Planning Application 3/2022/1129 Bridge Heywood Caravan Park

Planning application 3/2022/1129 FAO David Kilmartin

Earth bund and bench seating
Scale 1:200

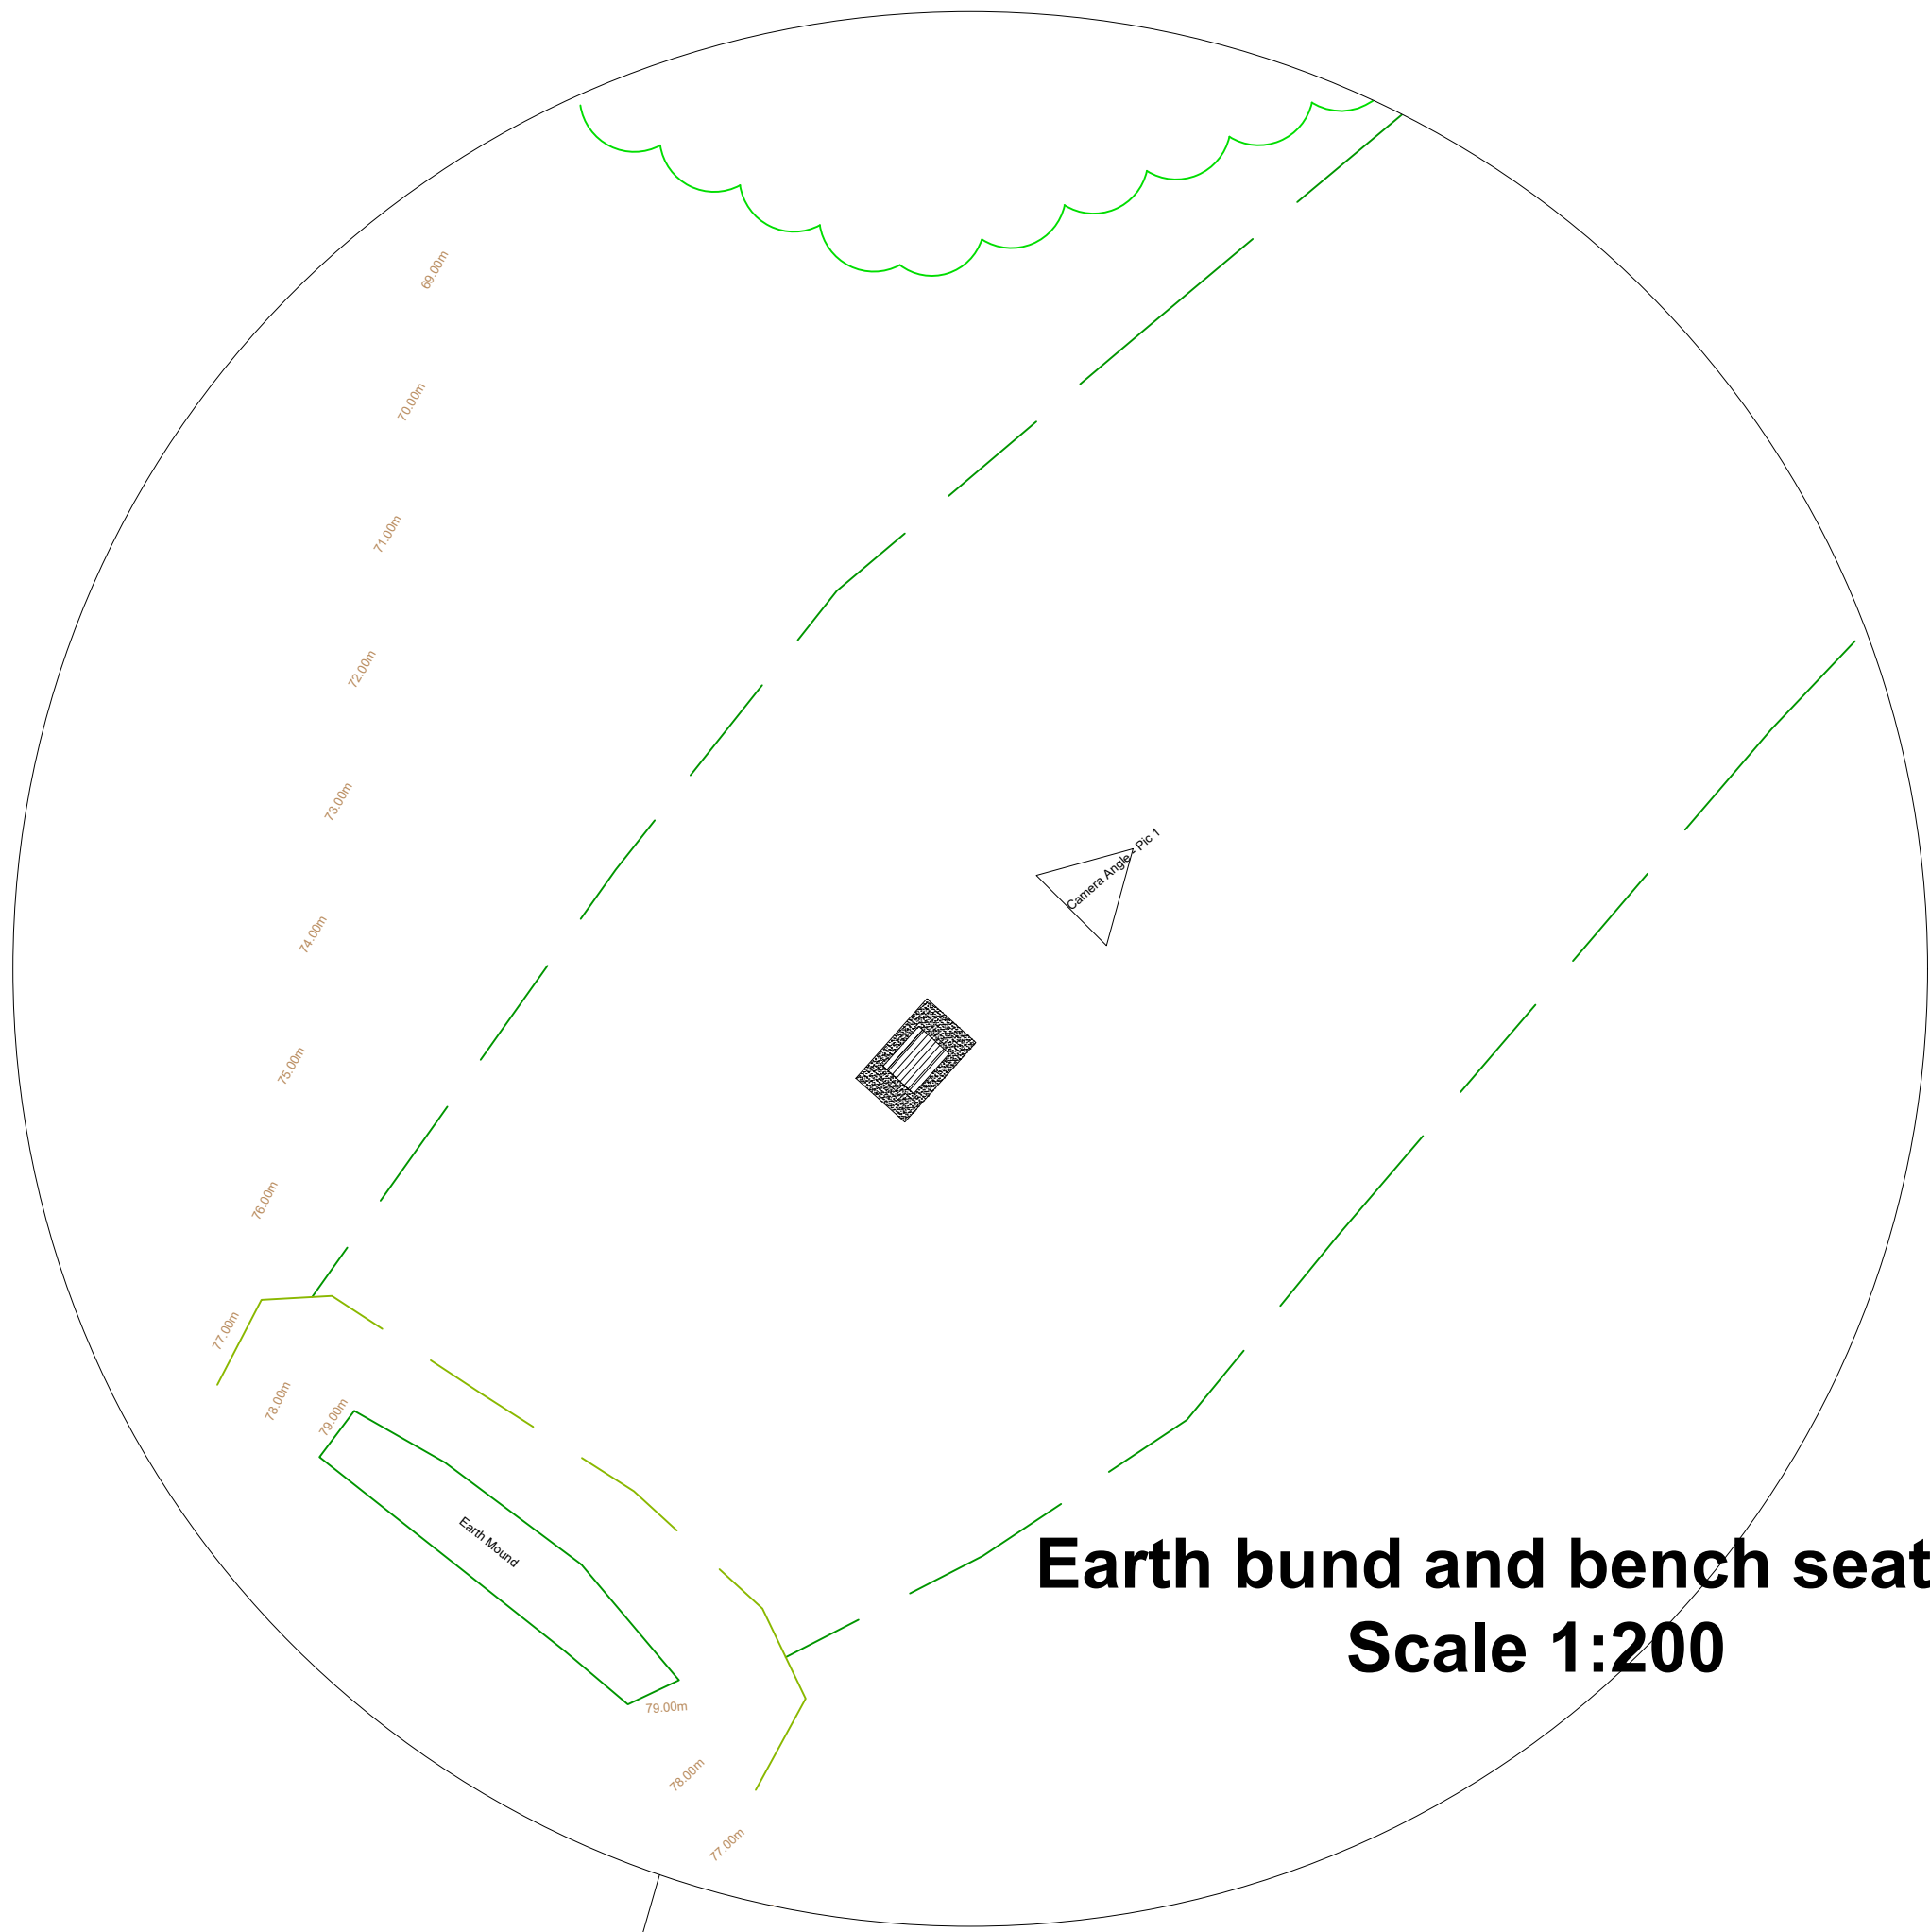
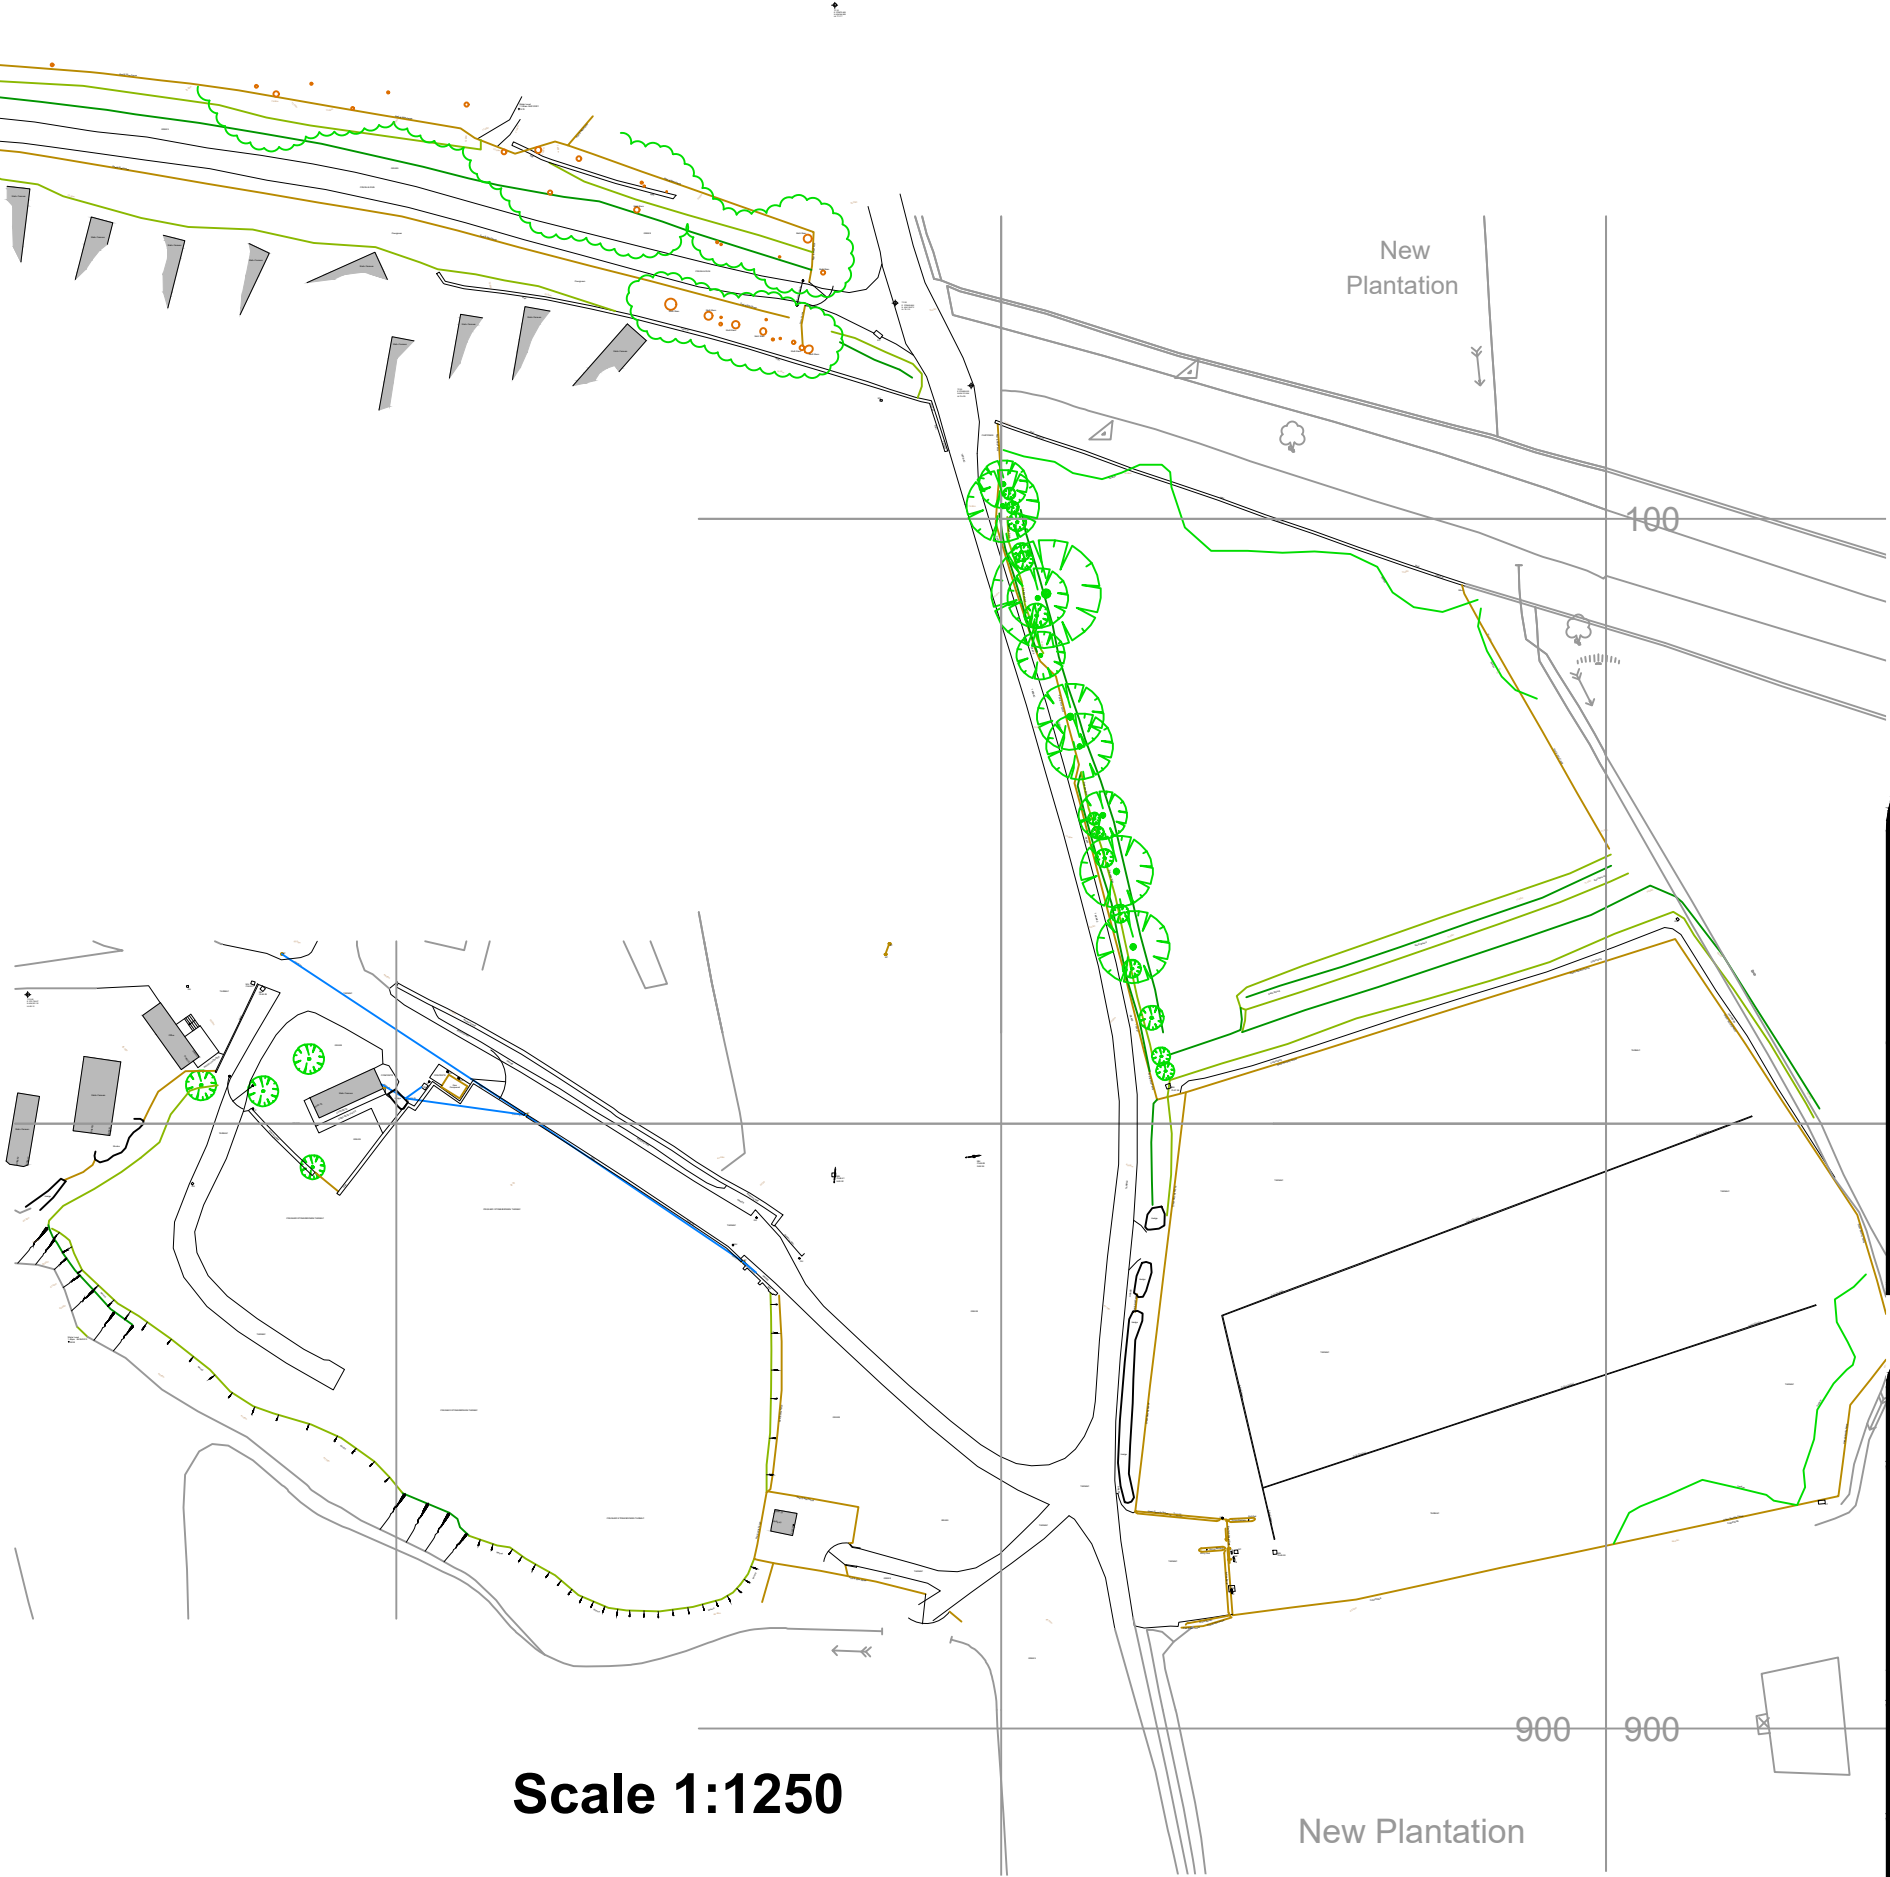
In order to maintain the structure of the viaduct access is required, and this access is via the northern end of the viaduct. The Title registry LA885684 Section A4 grants access. With the ditch being dug this now restricts the access. The removal of the earth to create the ditch could add to the decay and degradation of the viaduct. The removal of the earth was to prevent trespass onto the Landowners land. [REDACTED] have erected a 2m high fence, which stops anyone from crossing the viaduct onto the Caravan Parks land.

The applicant in the application under materials has indicated that No materials have been added, yet the creation of the path means that tonnes of hardcore material has been added in order to create the path.
